KITTITAS COUNTY

MEMORANDUM

TO: All Staff
FROM: Justin Turnbull, County Surveyor 
DATE: May 6, 2021
SUBJECT: County Survey Review 2 of BL-20-00020 Teanaway Ridge

# RECORD OF SURVEY

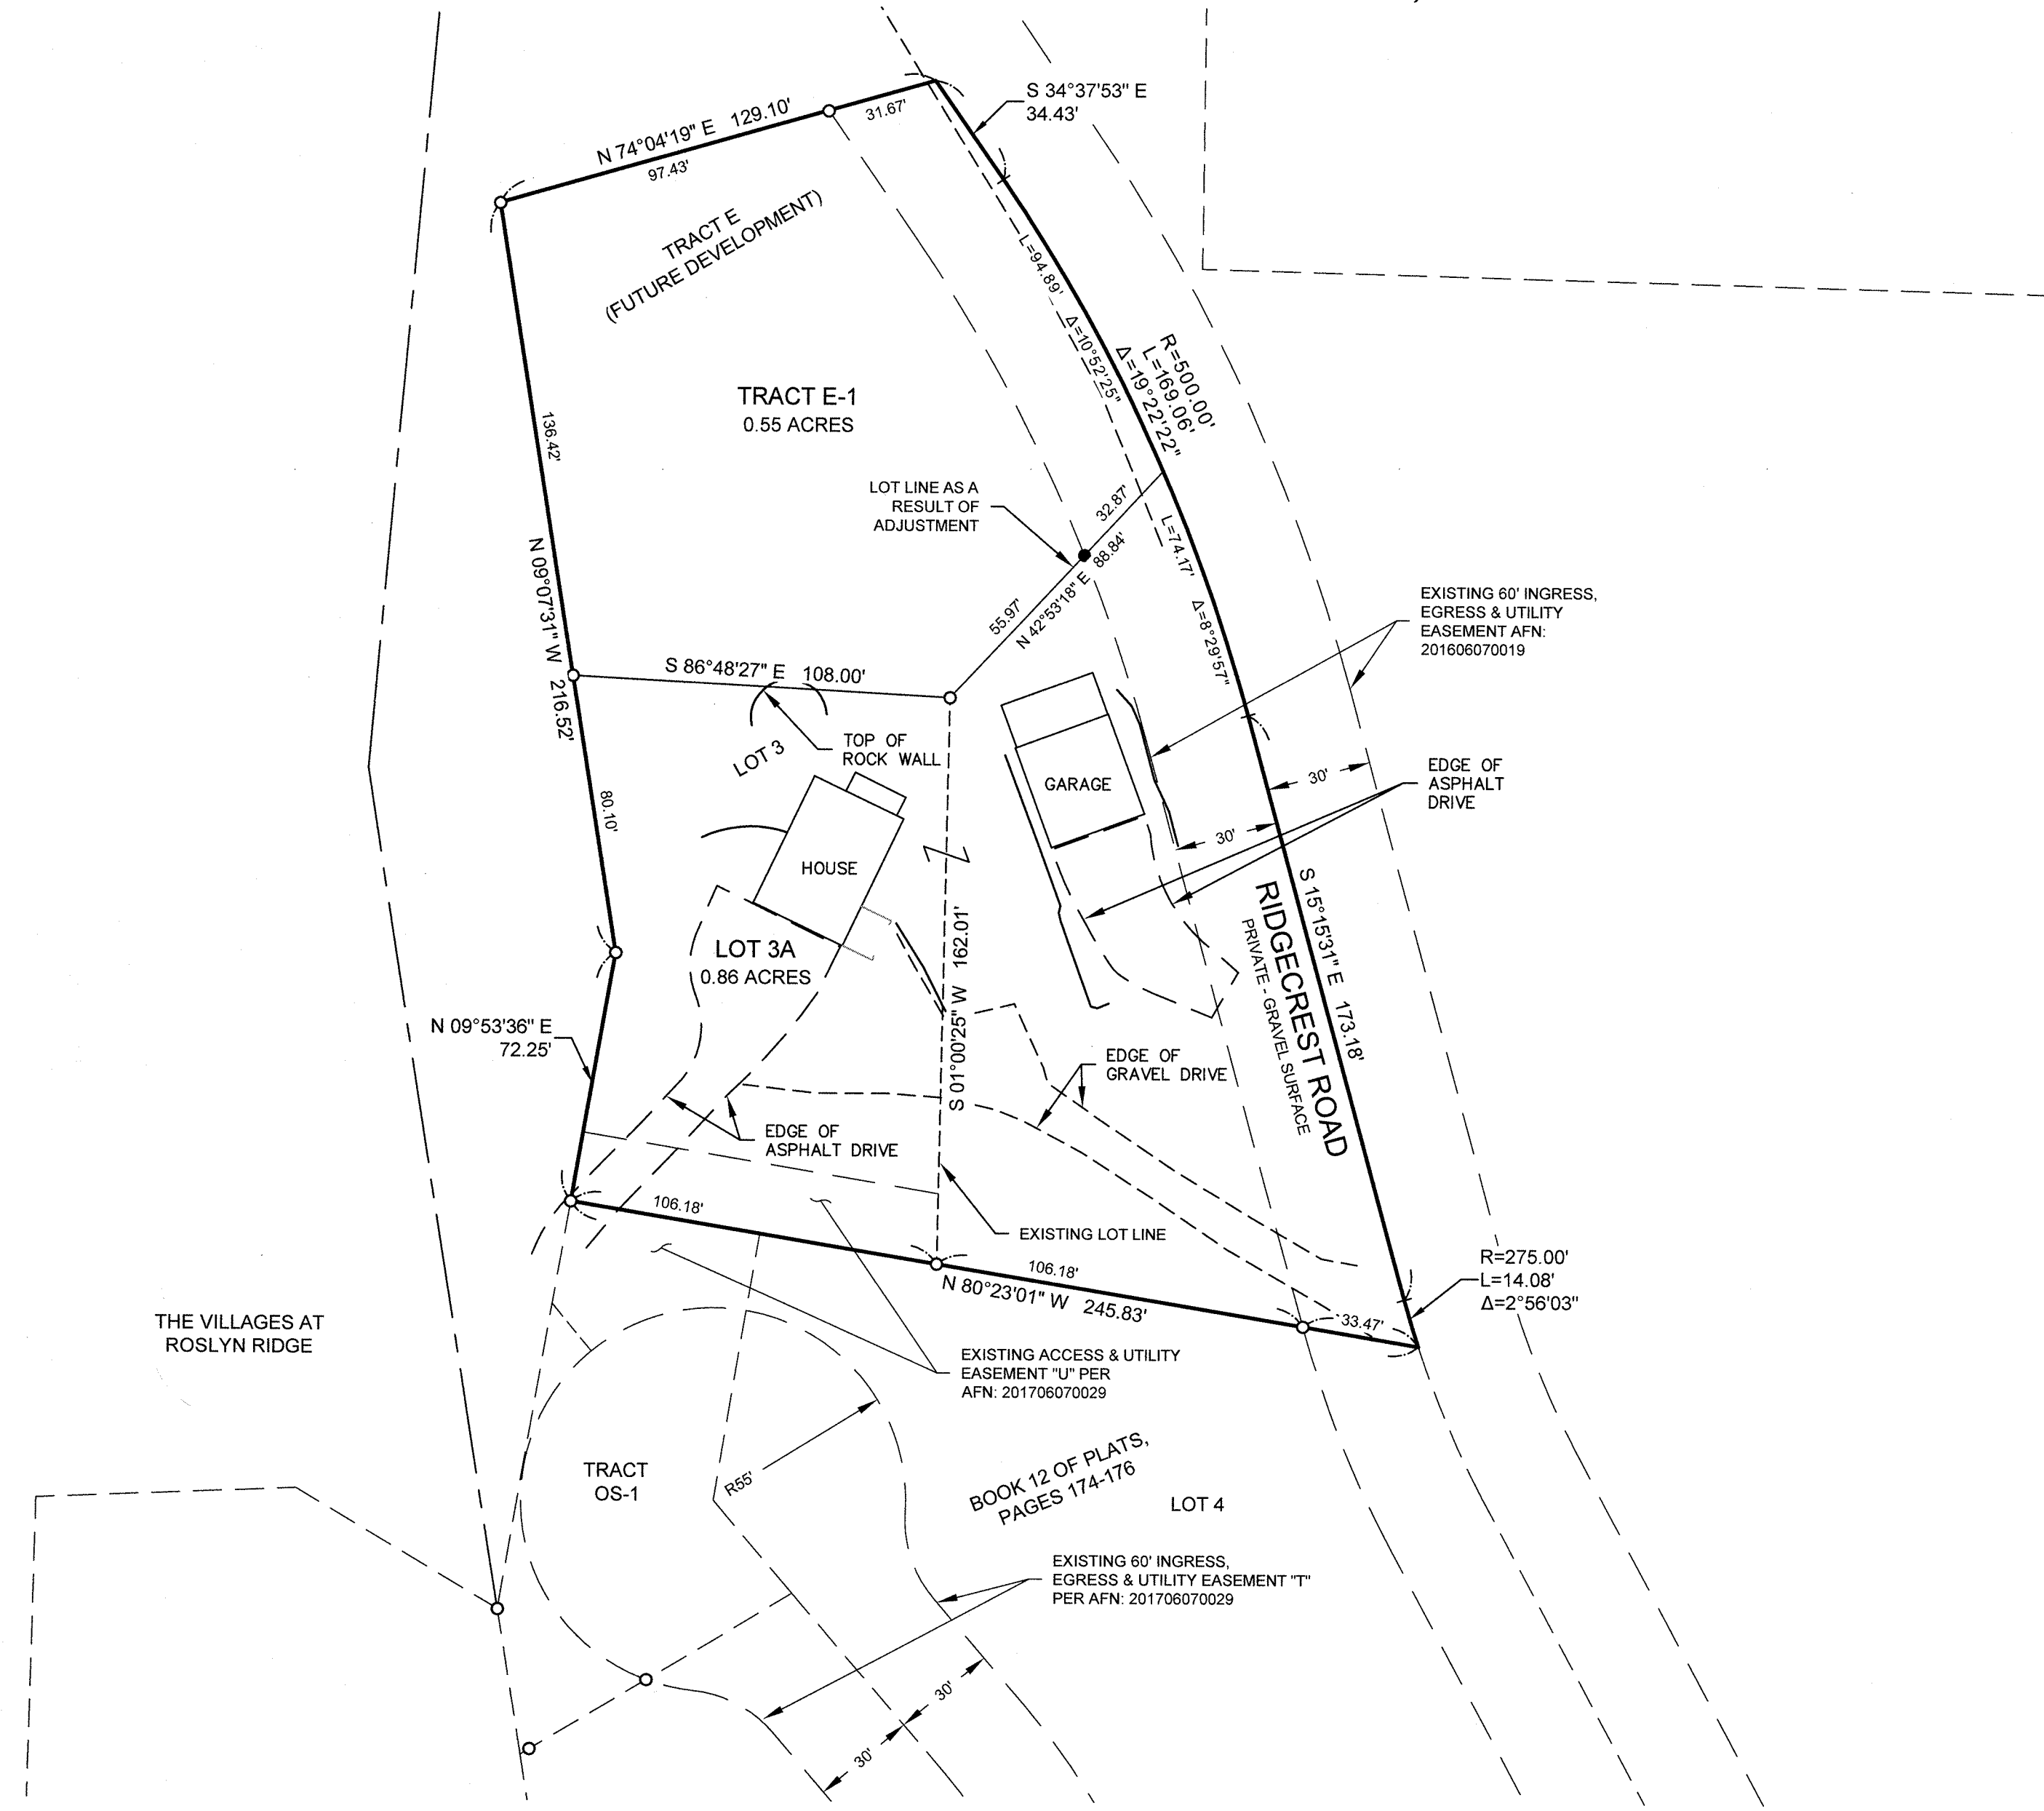
1. Basis of bearing not addressed.
2. Ridgecrest Road should be labeled.
3. Some of the lime labels are obscured by crossing linework.
